ENG-CDR20004-R1-CD-GEC-redlines.pdf Markup Summary

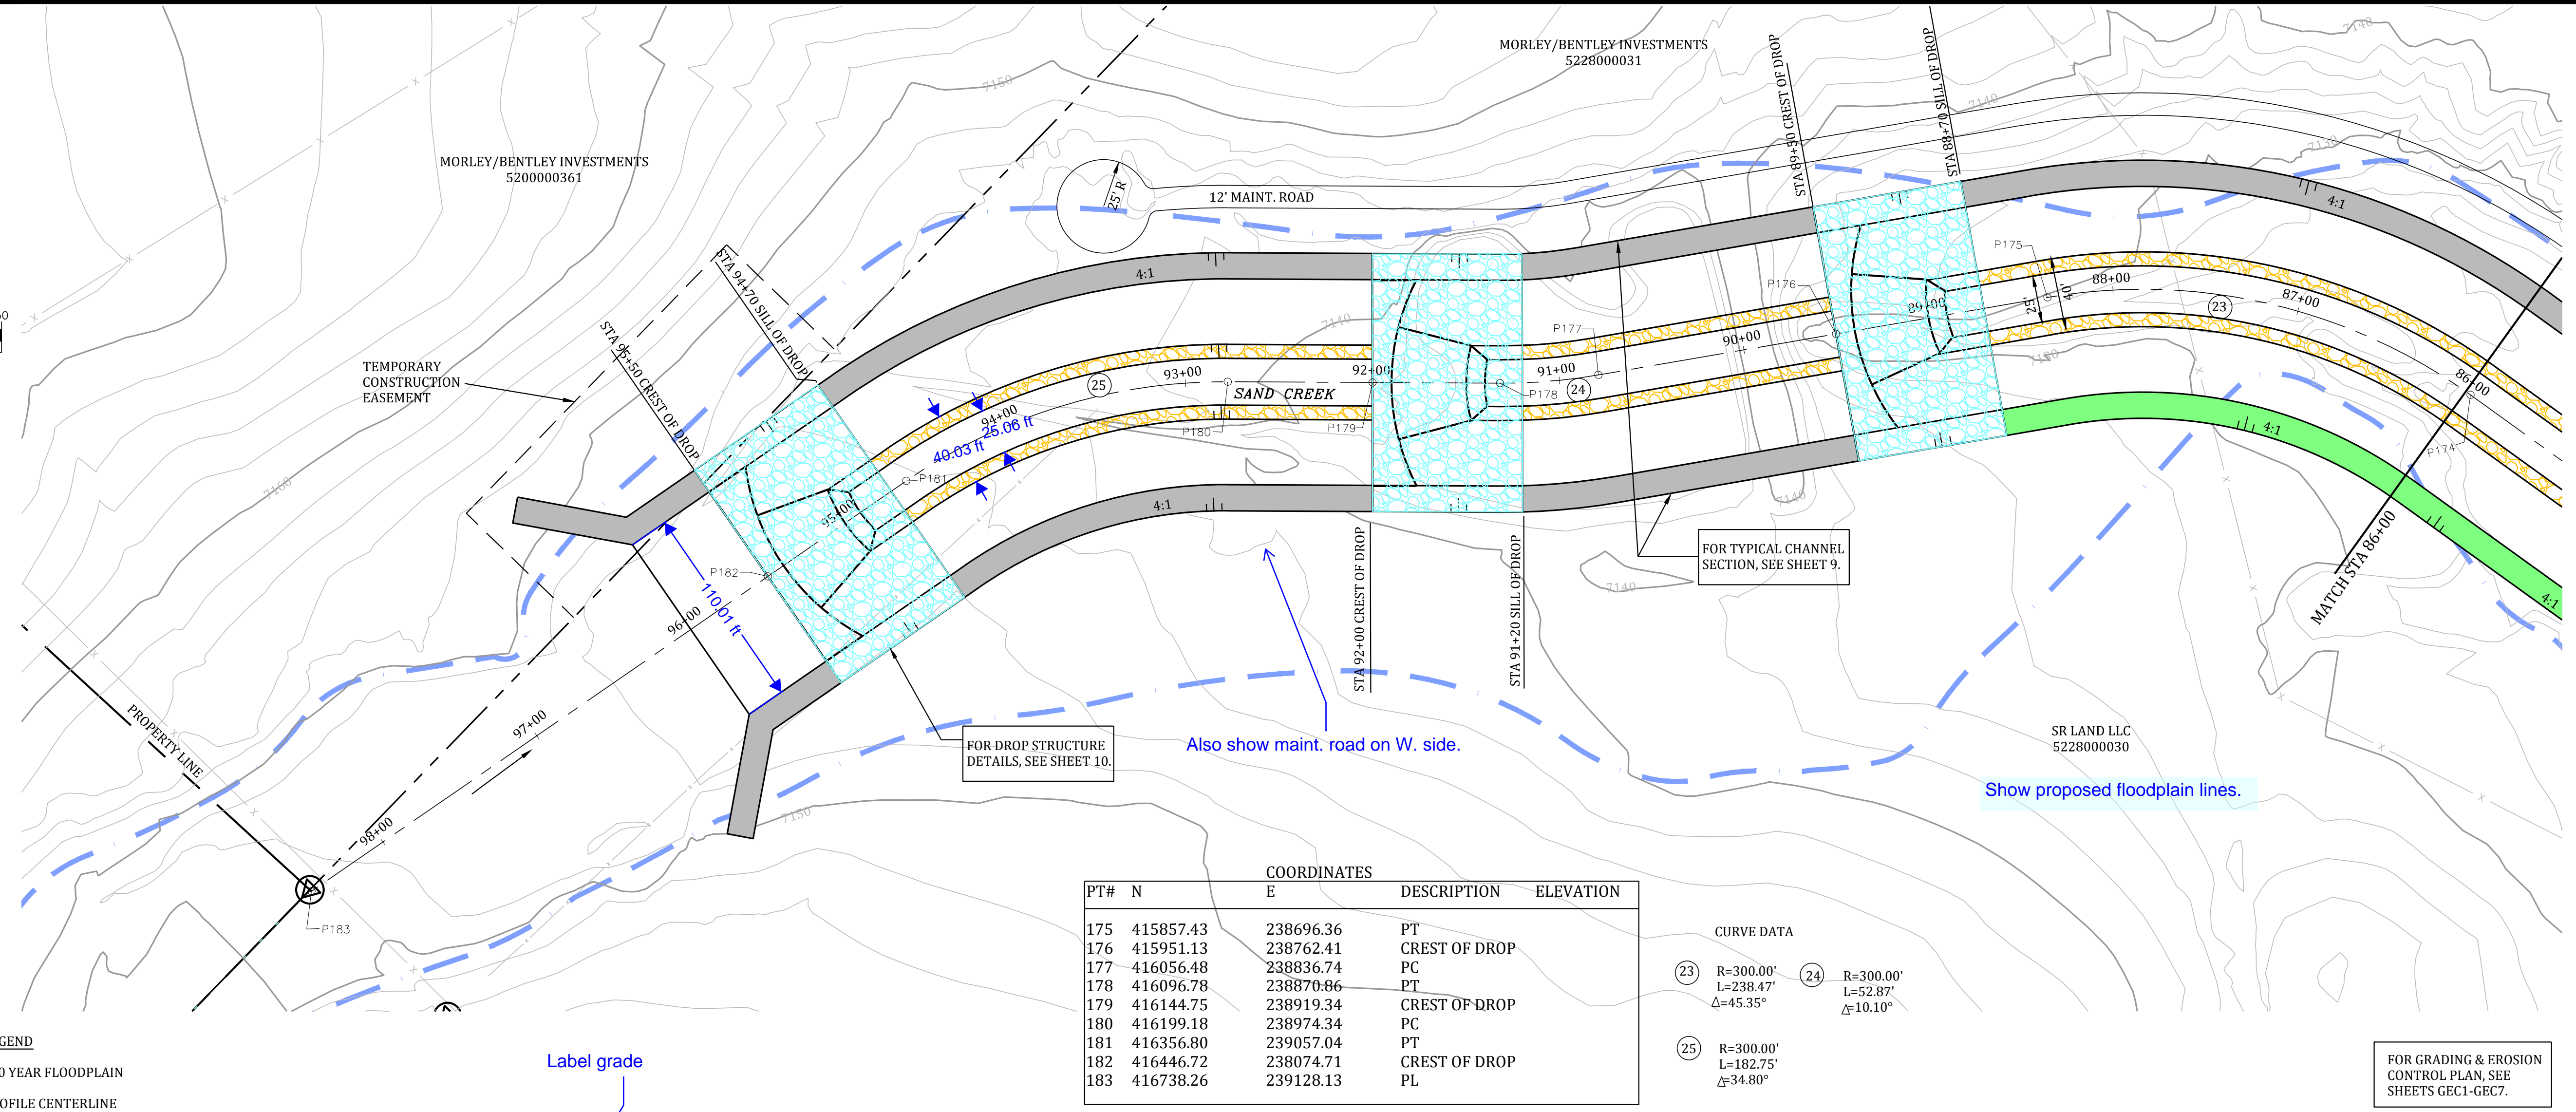
Show proposed floodplain lines.

Existing FEMA

Label grade

4:1?

Also show maint. road on W. side.

label elevations

SAND CREEK STABILIZATION, BRIARGATE BOULEVARD & STERLING RANCH ROAD BRIDGE DESIGN PLANS
STERLING RANCH DEVELOPMENT
DROP STRUCTURE DETAILS
 EL PASO COUNTY, COLORADO

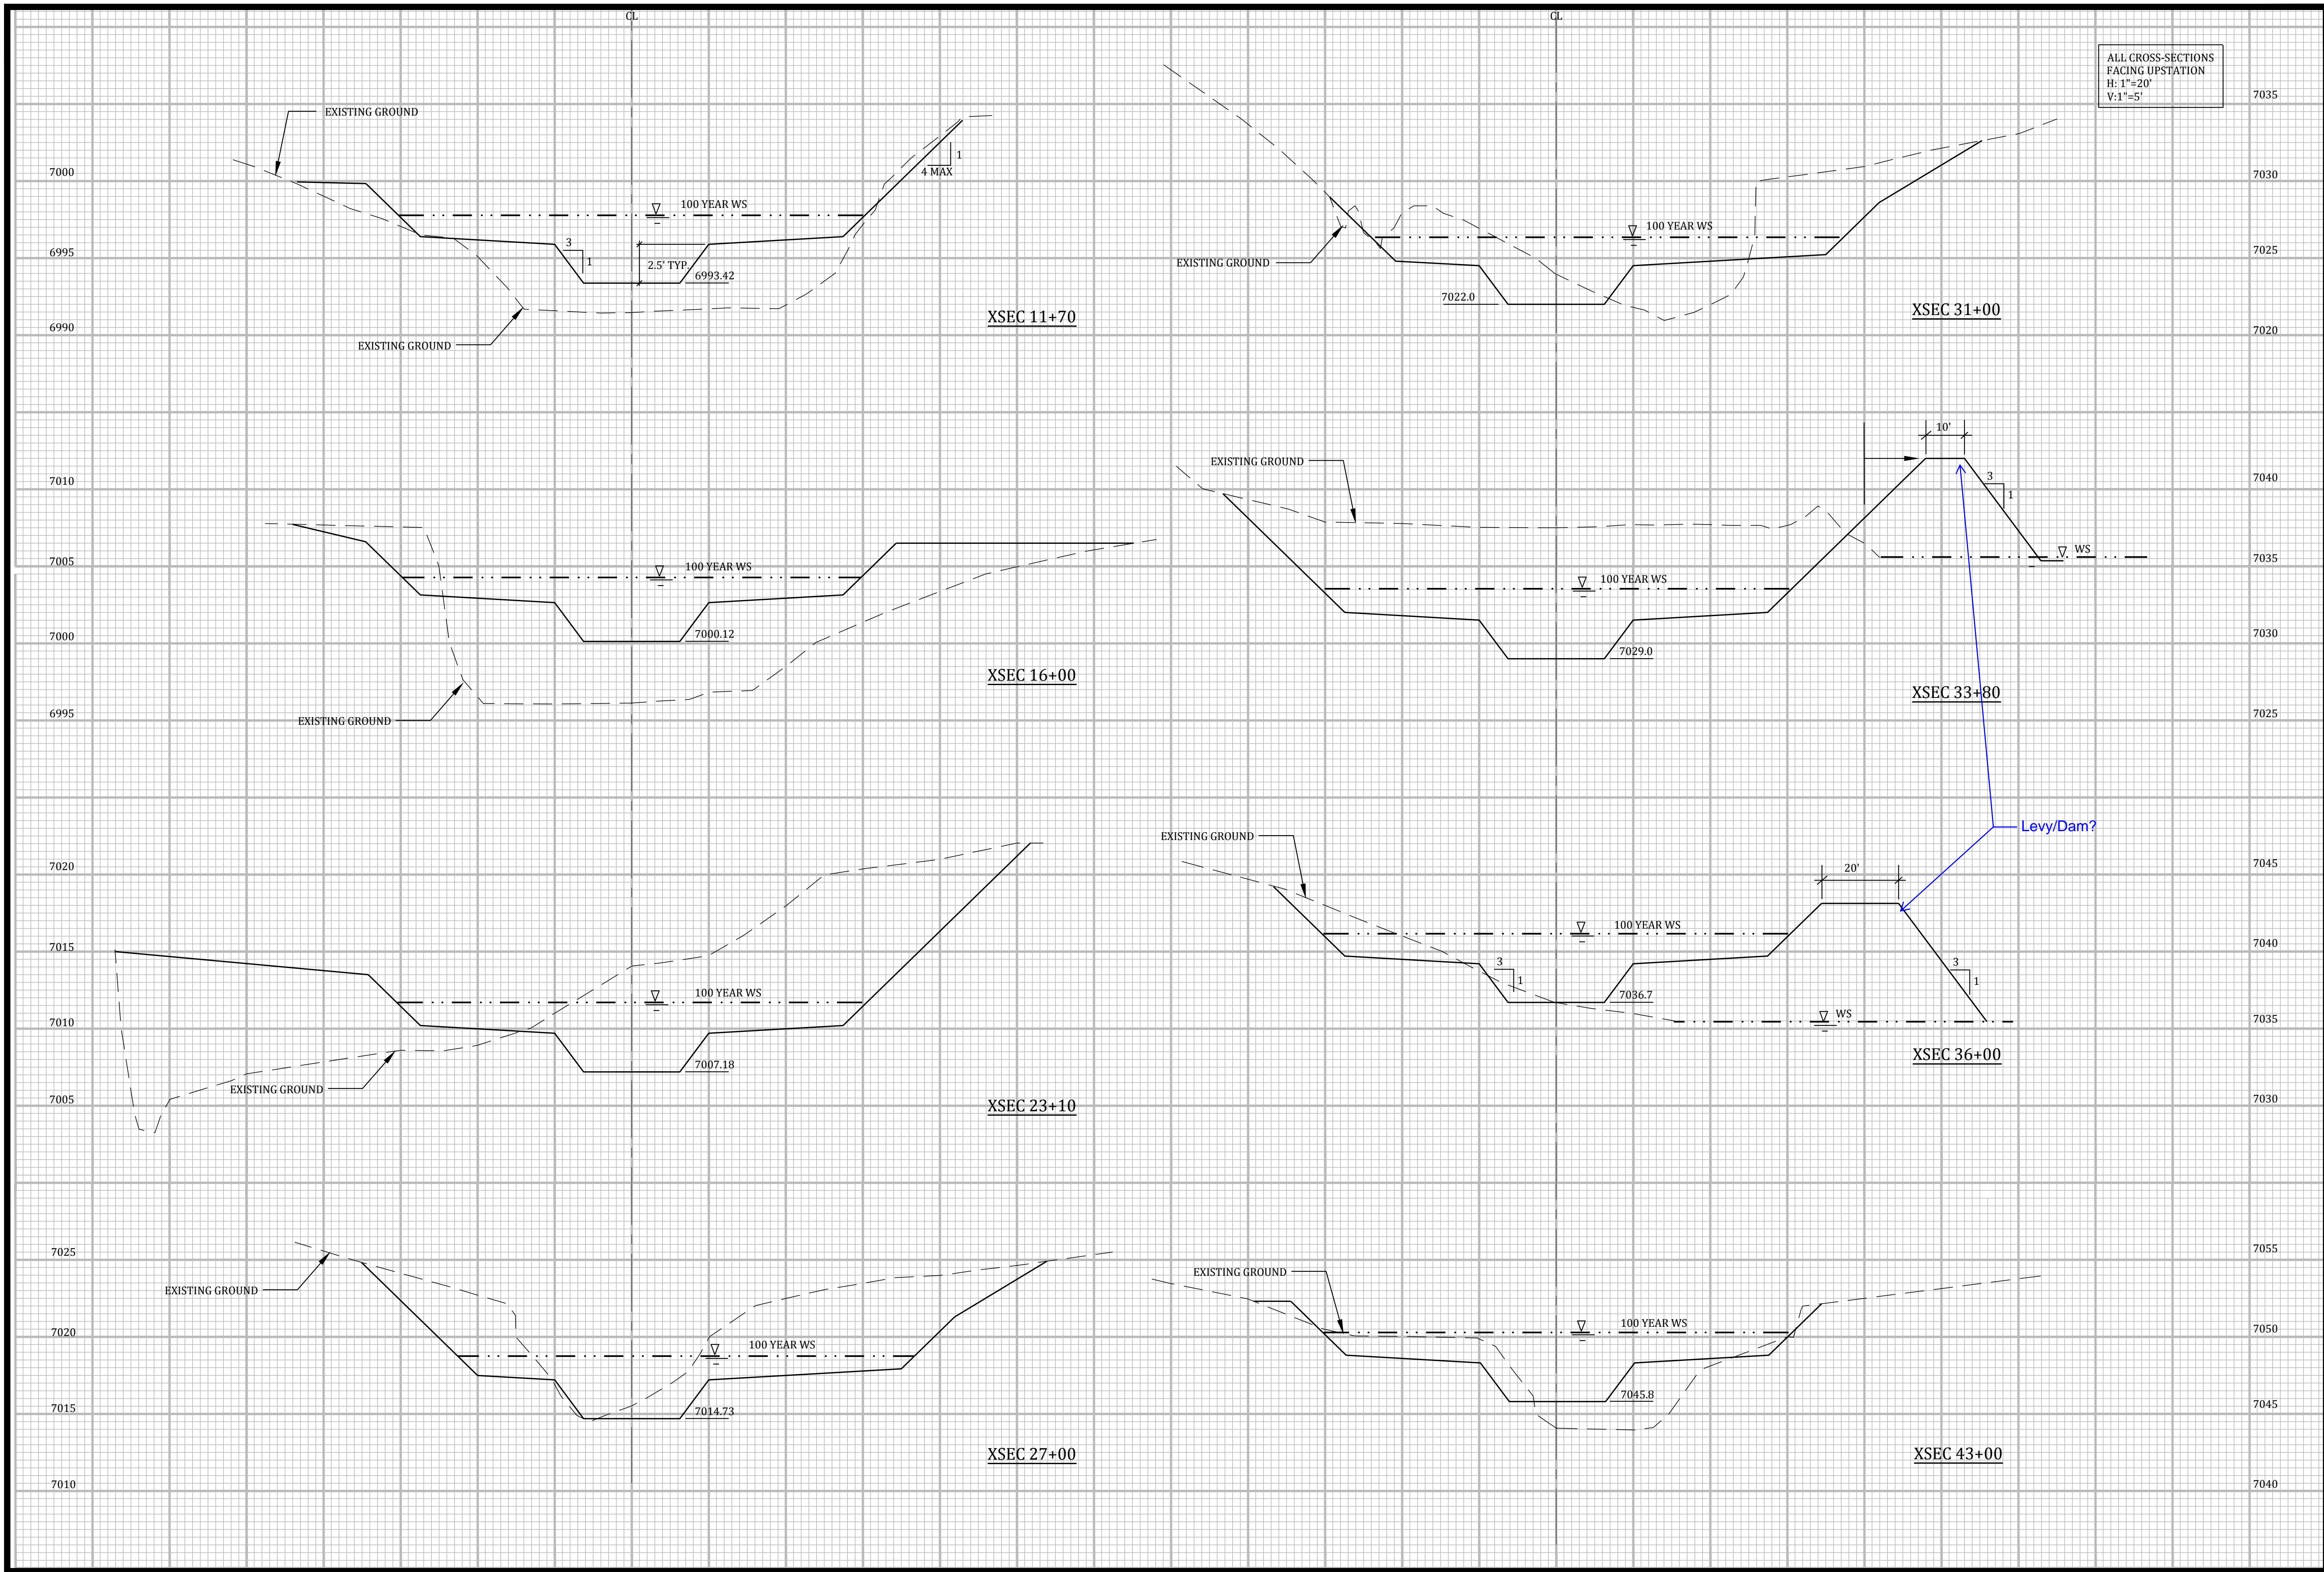
Subject: Callout Some channel depths are >7?
Page Index: 9
Date: 7/21/2020 1:18:59 PM
Author: dsdrice
Color: ■
Layer:
Space:
Page Label: 9

steeper than 4:1 requires fencing

See DCM Figure 10-20 or detail at right?

Soil riprap?

label slope
